**Date:** 10/31/2023

**To:** **Michael Francis**  
Dan Ryan Builders  
3000 RDU Center Drive  
Morrisville, NC 27560  
mfrancis@drbgroup.com  
919-500-3883

**Re:** **Window Header Issue**  
Location: Lot 44 Honeycutt Hills (Angier, NC)  
JDS Project No.: RDU2310464  
Date of Inspection: 10/31/2023

SHEET No. A.II

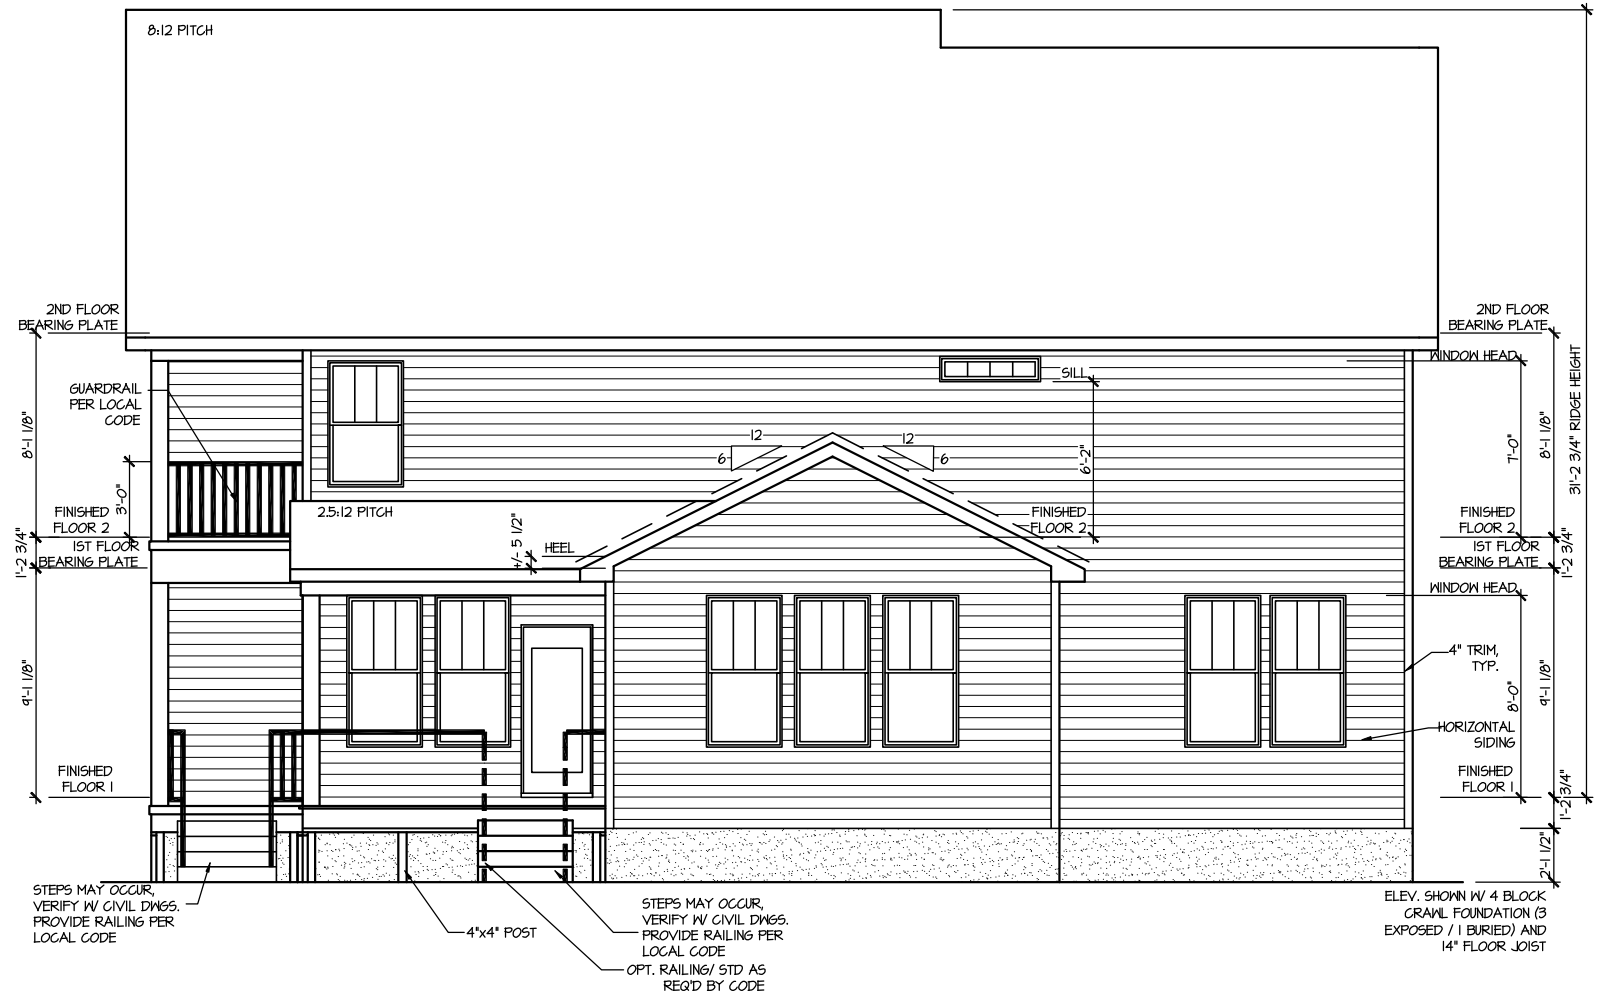
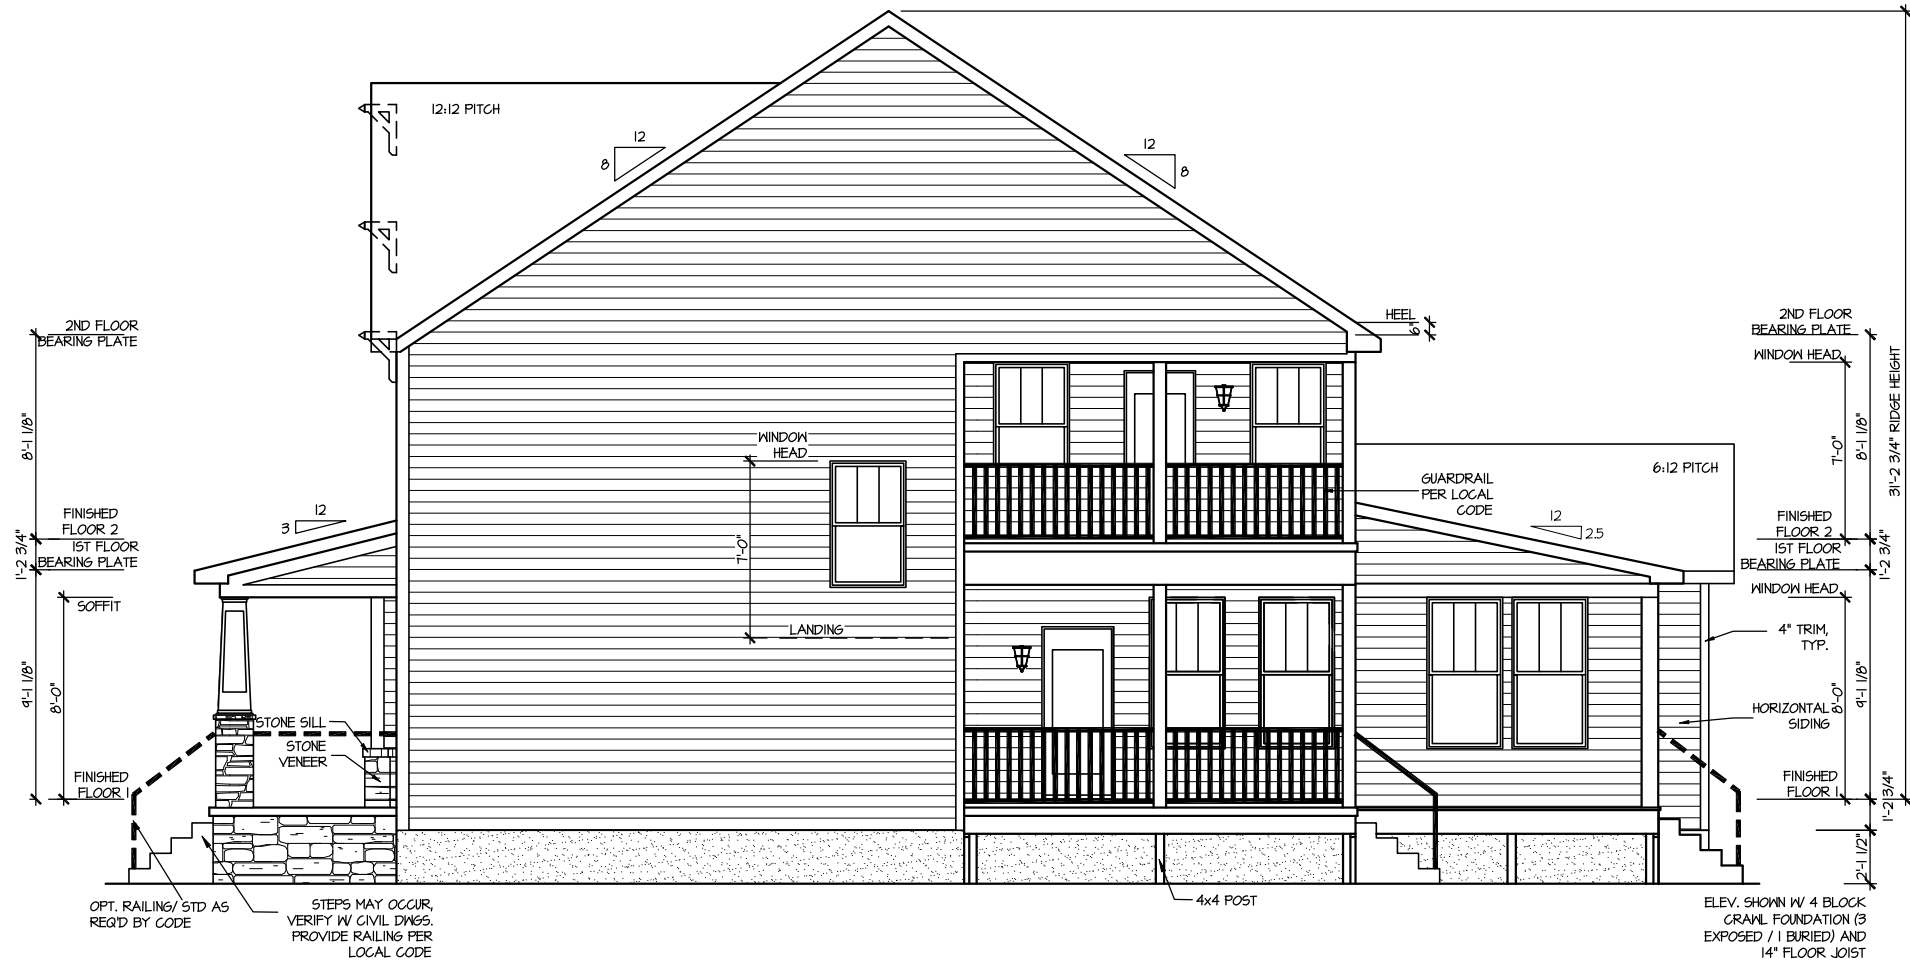
- Installed the window headers above the family room, breakfast room, and the loft with (1) jack stud and (1) king instead of installing with (1) jack stud and (2) king studs per the building plans.

Based on our on-site evaluation and review, Install (1) Simpson CS16 strap on the jack studs between the windows at all locations. The straps shall extend from the top plate across the header and extend 12" onto the jack stud below, install the strap per the manufacturer's installation instructions.
